PLAN REVIEW SHEET

Petition #: RZP 2021-015

Address: 3010 West Boulevard

Request: R-22 MF (CD)

**SKETCH PLAN PRIVATE ALLEY OPTION**

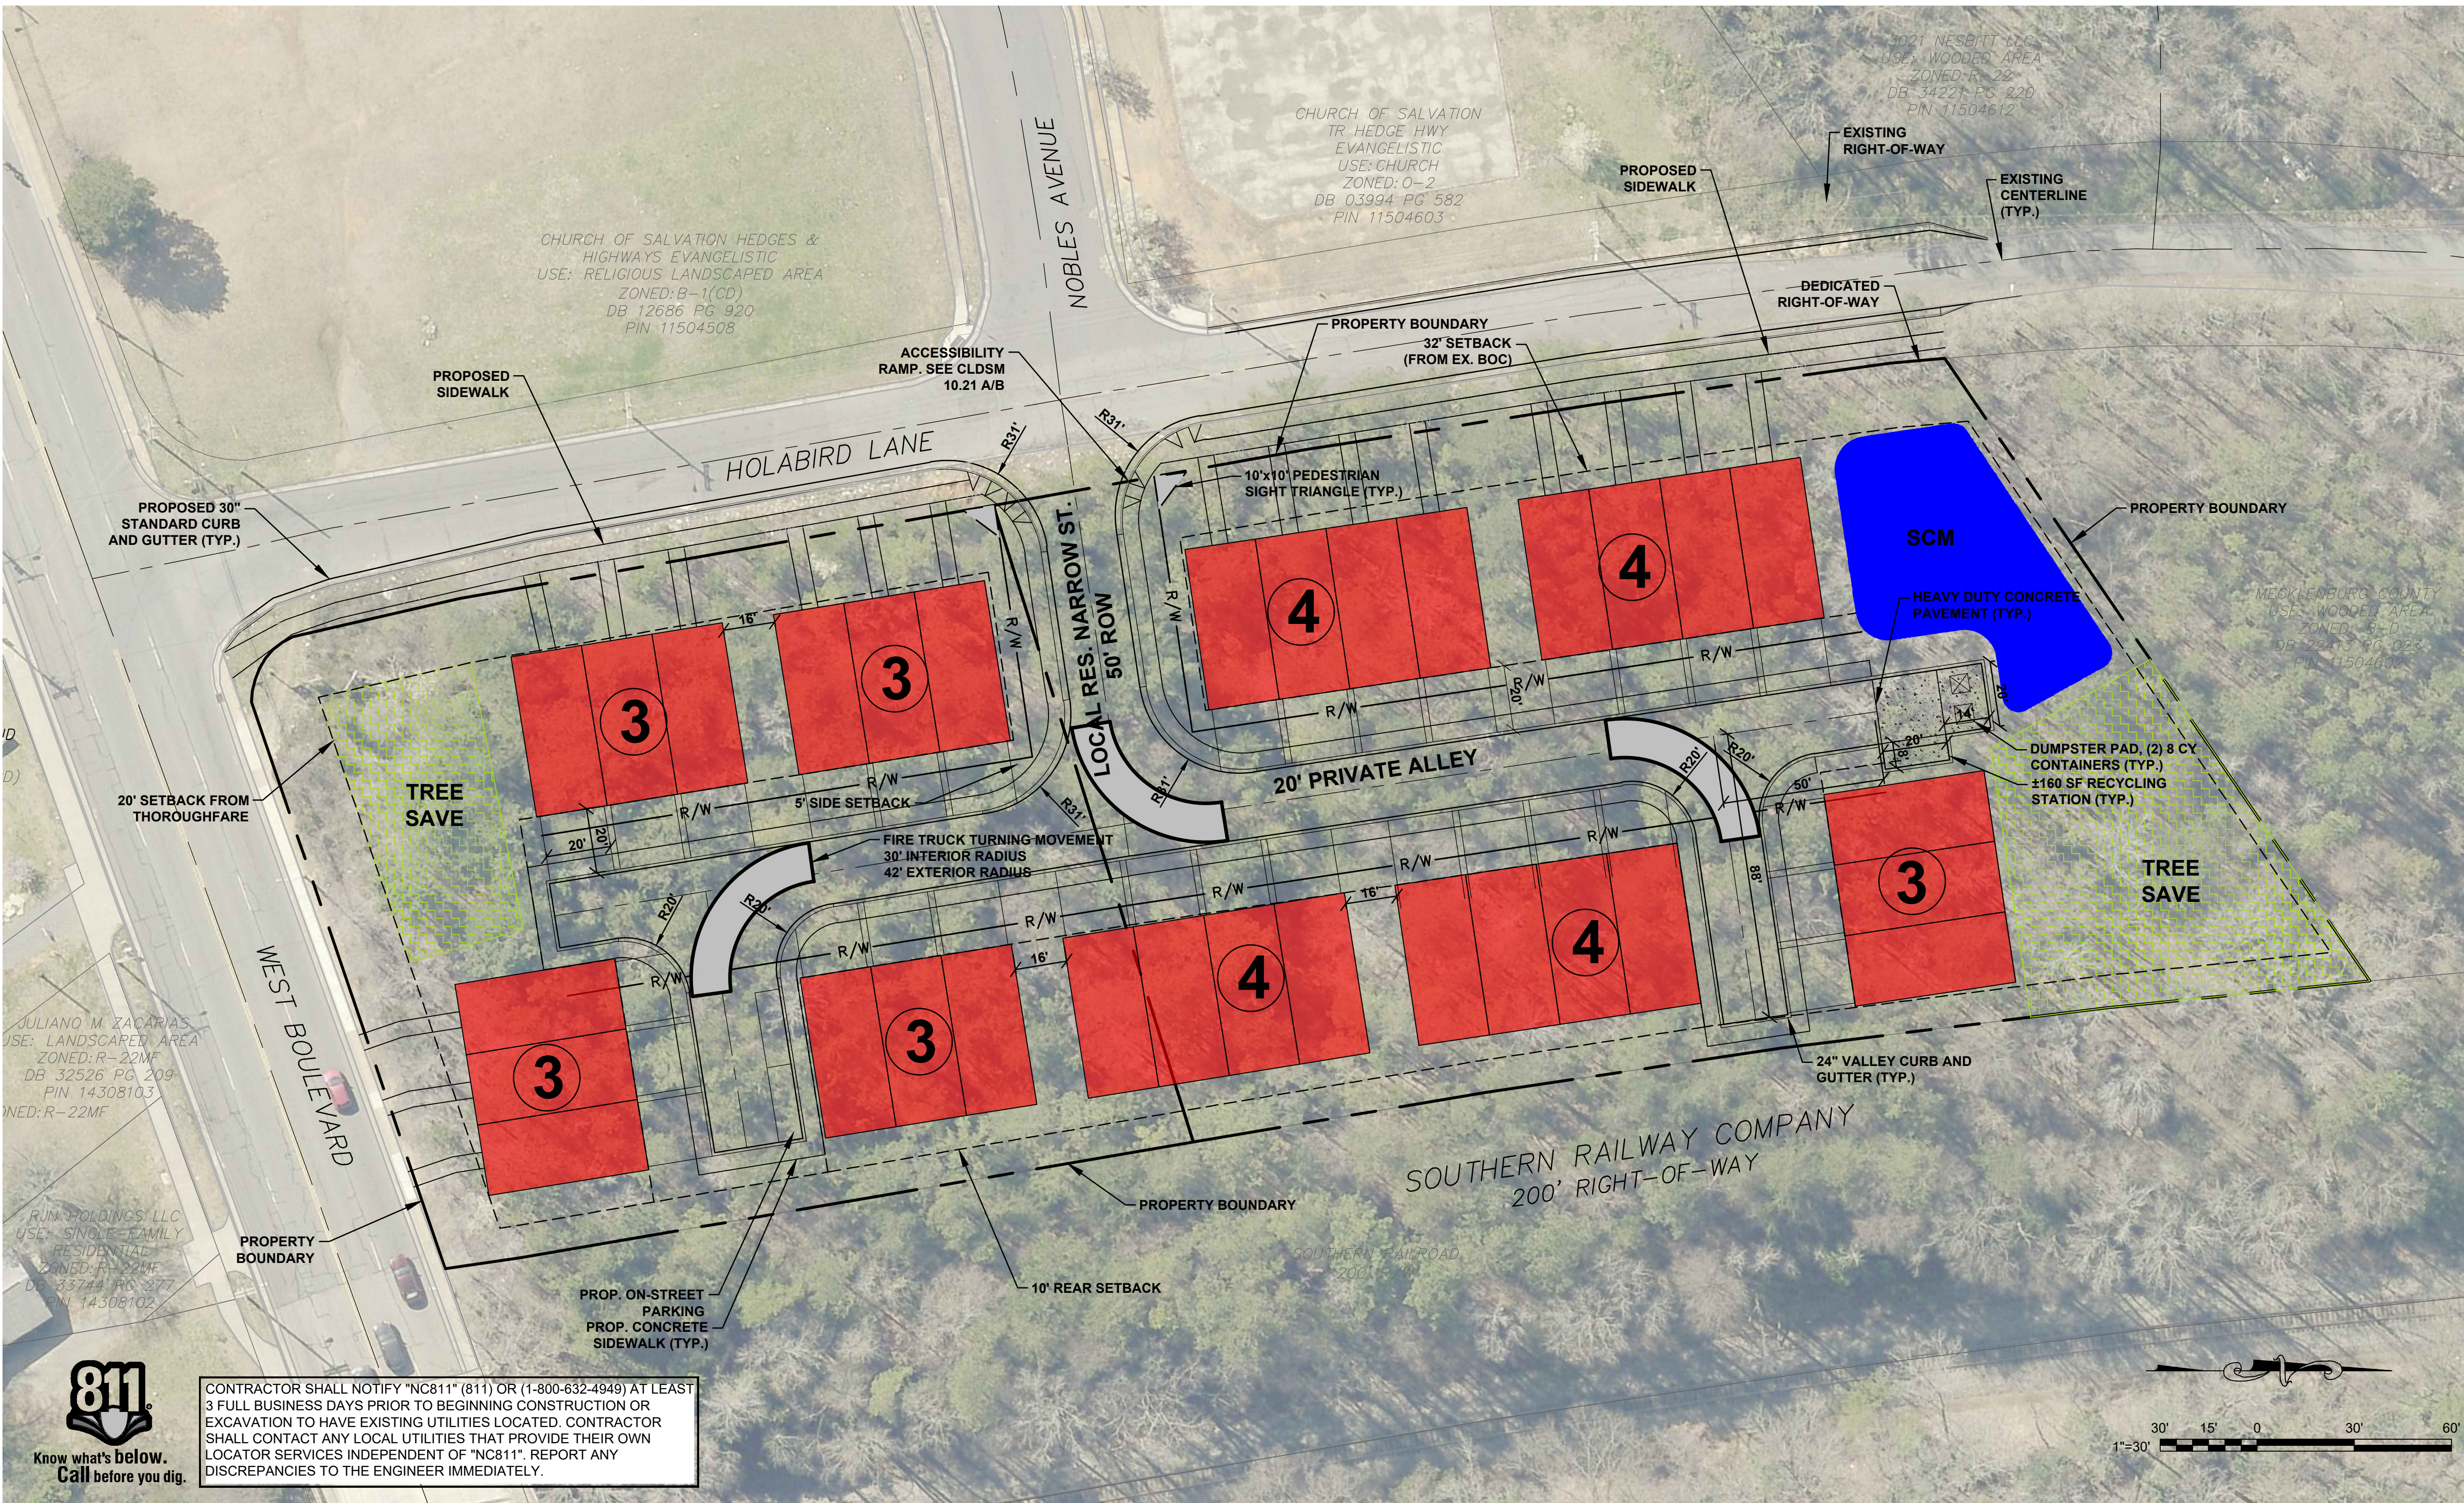
The site is located along CATS local bus routes #10 and #235 along West Boulevard. CATS requests the construction of an ADA compliant bus and shelter pad per Land Development Standard 60.03A. The final location of the pads will be coordinated with the developer through the permitting process.
